Re: Alesco Senior College Argenton (SSD-9683) - Response to Submissions

With respect to your correspondence dated 26th July and the abovementioned State Significant Development for Alesco Senior College at 7 James Street, Argenton, please find attached a response to the various agency and public submissions made to the proposal.

Figure 10 | Proposed Landscaping and Fencing Plan (Source: Applicant's RtS)

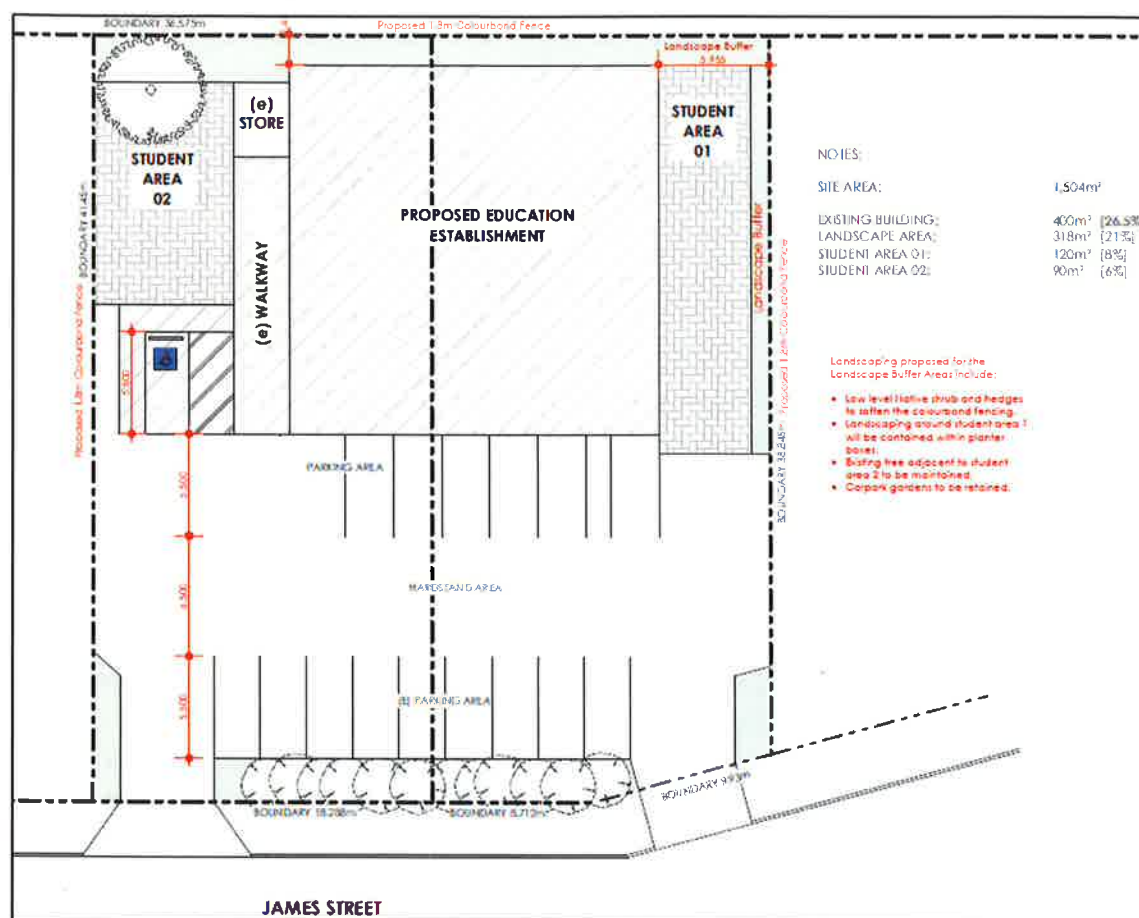
• Dimensions of accessible and ambulant toilet facilities	
<p>Landscape Design</p> <p>No detailed site-wide landscape strategy has been provided as per the NSW Government Planning Secretary's Environmental Assessment Requirements. The area allocated for landscape planting is approximately 10.6% of the site. Given the importance of external learning spaces to wellbeing and outlook from the school building, a Landscape Plan addressing the design quality principles in SEPP 2017 is required to demonstrate how the landscaping compliments the site as a learning environment. In this regard, it is noted that the site has limited capability to accommodate adequate landscaping.</p> <p>Both outdoor spaces are bordered by 1800mm Colorbond fence which is a harsh and unsympathetic boundary definition. Minimum 1m wide planting areas are recommended for the establishment of soft landscape including trees that provide amenity, outlook, shade and create an attractive and pleasant learning environment. The location of the existing tree to the rear is to be accurately identified and the landscape design should cater for the long-term viability of this tree.</p> <p>It appears that the proposed disabled car park could be located in line with existing car park bays, allowing further space to be recovered for outdoor learning space.</p>	<p>It is proposed to retain vegetation existing vegetation on the site.</p> <p>Planting is proposed to soften the impacts of the colourbond fencing and to also provide an increased buffer to adjoining residential properties.</p> <p>A full landscape design can be conditioned prior to Occupation Certificate if deemed necessary.</p> <p>Landscaped areas and fence alterations are noted on the plan contained within Attachment E.</p>
